From: Maria Tomalova
Sent: 26 January 2022 12:14
To: Chris Moore [REDACTED]
Subject: FW: BR/3/22/DOC

PROPOSED SOUTH WEST ELEVATION

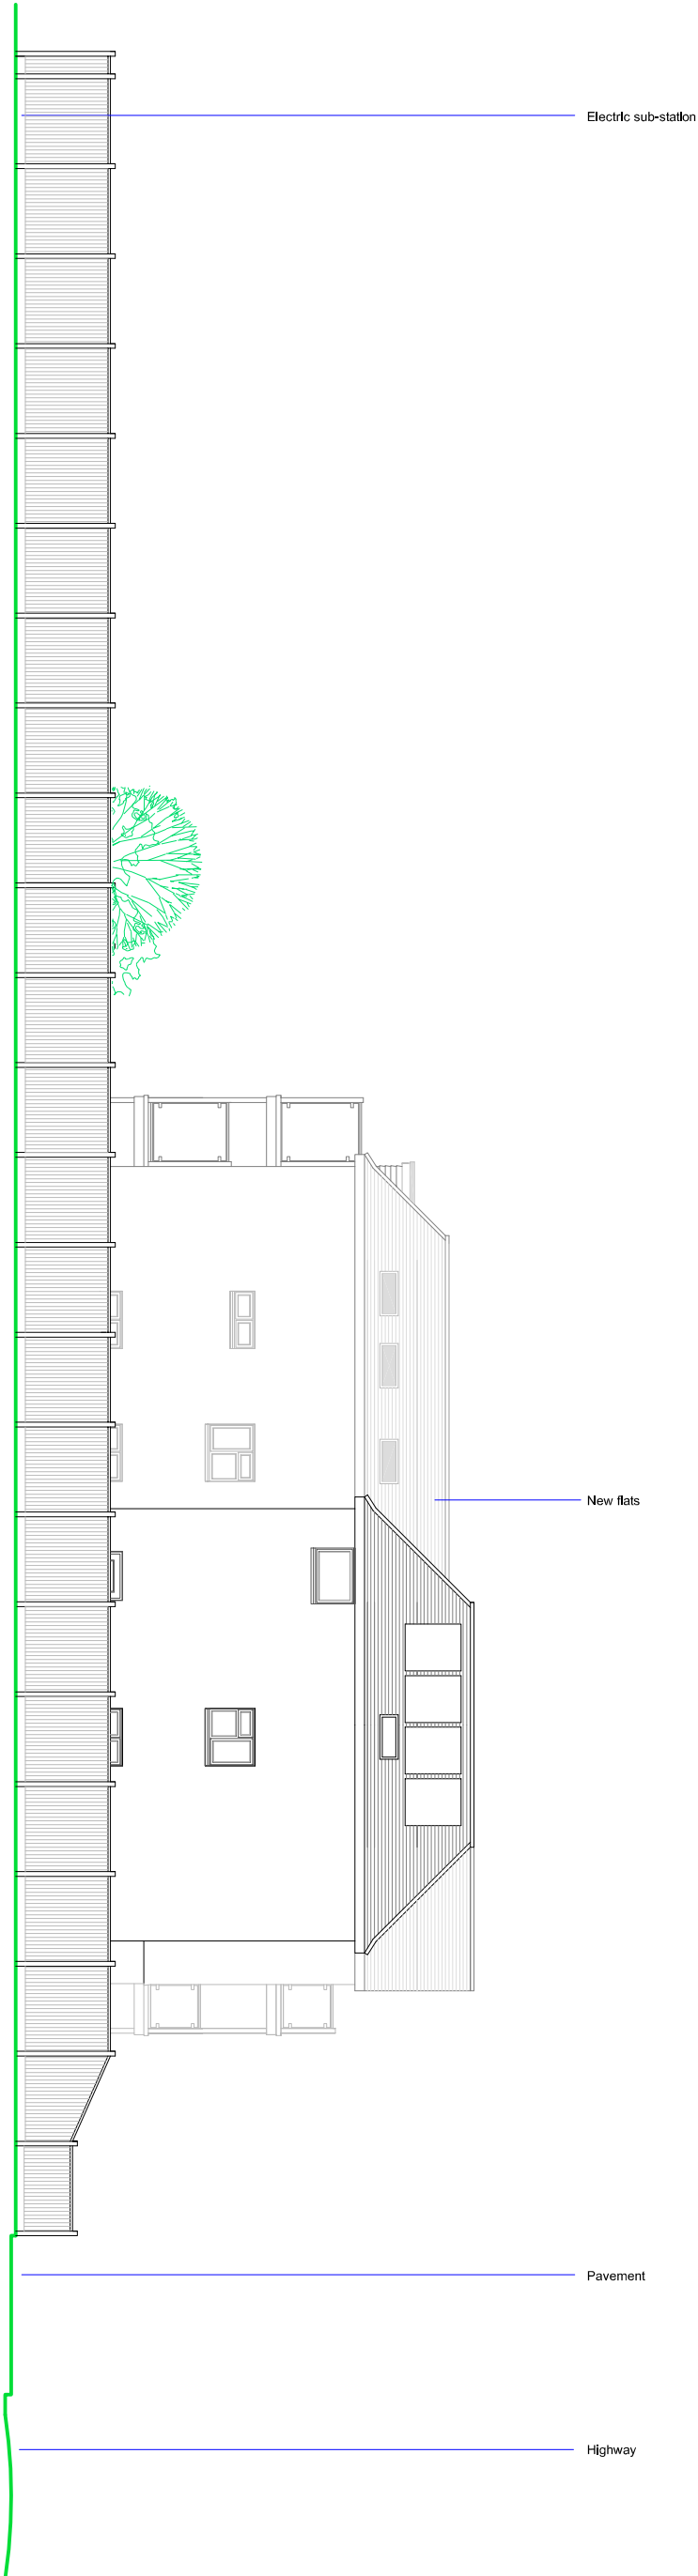
No noise assessment has been submitted to identify the background or environmental noise level, specific noise level at façade of nearest receptor, impact to receptor or the performance required from an acoustic fence.

Most unmodified cars engine noise level when idling is below 50 dBA – this is within the WHO criteria for external noise levels. Acoustic fencing should have a mass of 10kg/m². Closed board acoustic fencing (with a mass of 10kg/m²) at a height of 1.8 meters (as proposed) shall be sufficient to reduce noise levels to an acceptable level.

The height of the fence should be sufficient to mitigate the impact from the headlights – providing the approach/driveway to the proposed development is not at a significantly higher level than the properties on Hillsboro road.

PROPOSED SITE/LANDSCAPE PLAN

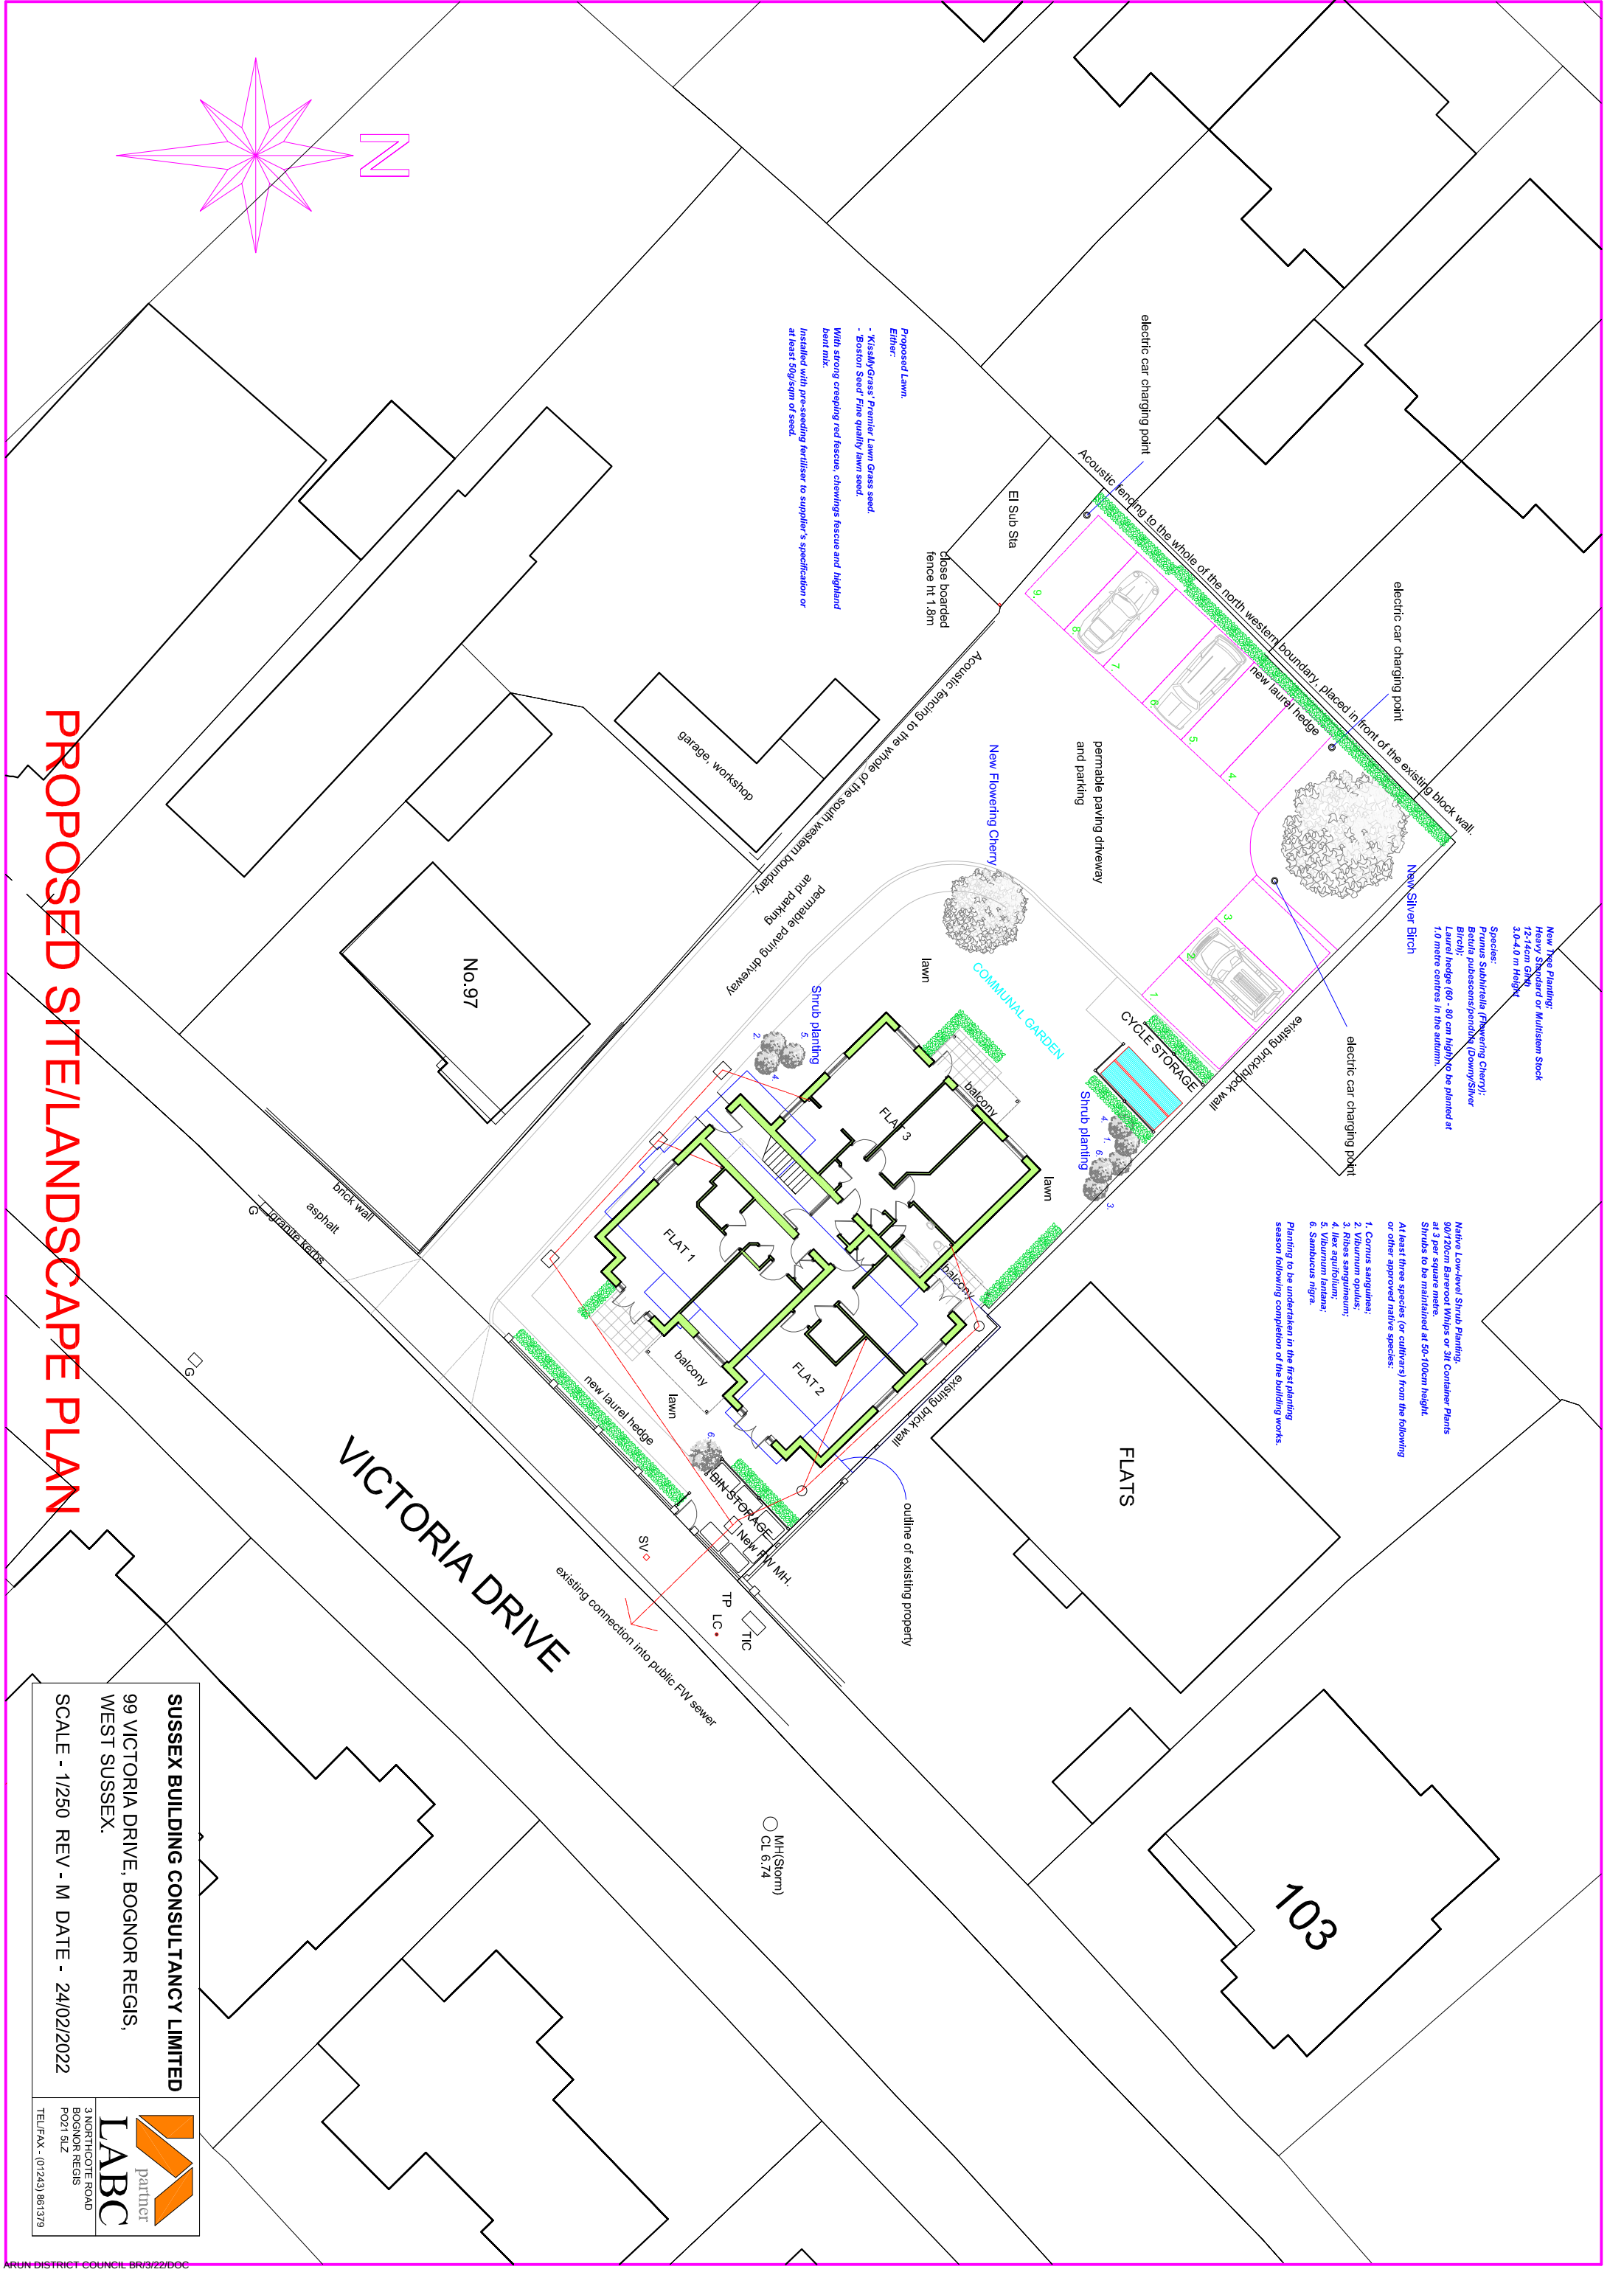
I am afraid the drawing you sent me recently is not sufficient to discharge this condition.

I am 100% sure that laurel hedge is entirely useless in terms of noise (visual effect only).

It was proofed that 10m deep row of trees with hedges in the between, densely grown will take 1decibel only!

What we expect in this case is the details of the proposed acoustic fence which will be assess by Environmental Health Office.

14. As presently submitted the appeal scheme does not do this adequately. For example, on the Proposed Site Plan the boundary with Nos. 97 & 95 is simply labelled 'acoustic fencing' and the rear boundary with the pair of semi-detached houses in Hillsboro Road shows the retention of the existing concrete block wall and the planting of a hedge. I do not consider that enough thought has been given to the safeguarding of neighbours from the effects of car parking, including noise and headlights, and this deficiency if it remained would warrant dismissal of the appeal.

What you provided is not evidently enough for discharging this condition (9)

I have spoken with the client and we have now added the acoustic fencing across the rear boundary of the site. As you will see, I have kept the existing block wall with the acoustic fencing to be placed in front of this and the proposed laurel hedge in front of the fence. I am sure that the combination of these three elements will provide ample sound insulation to those properties behind.
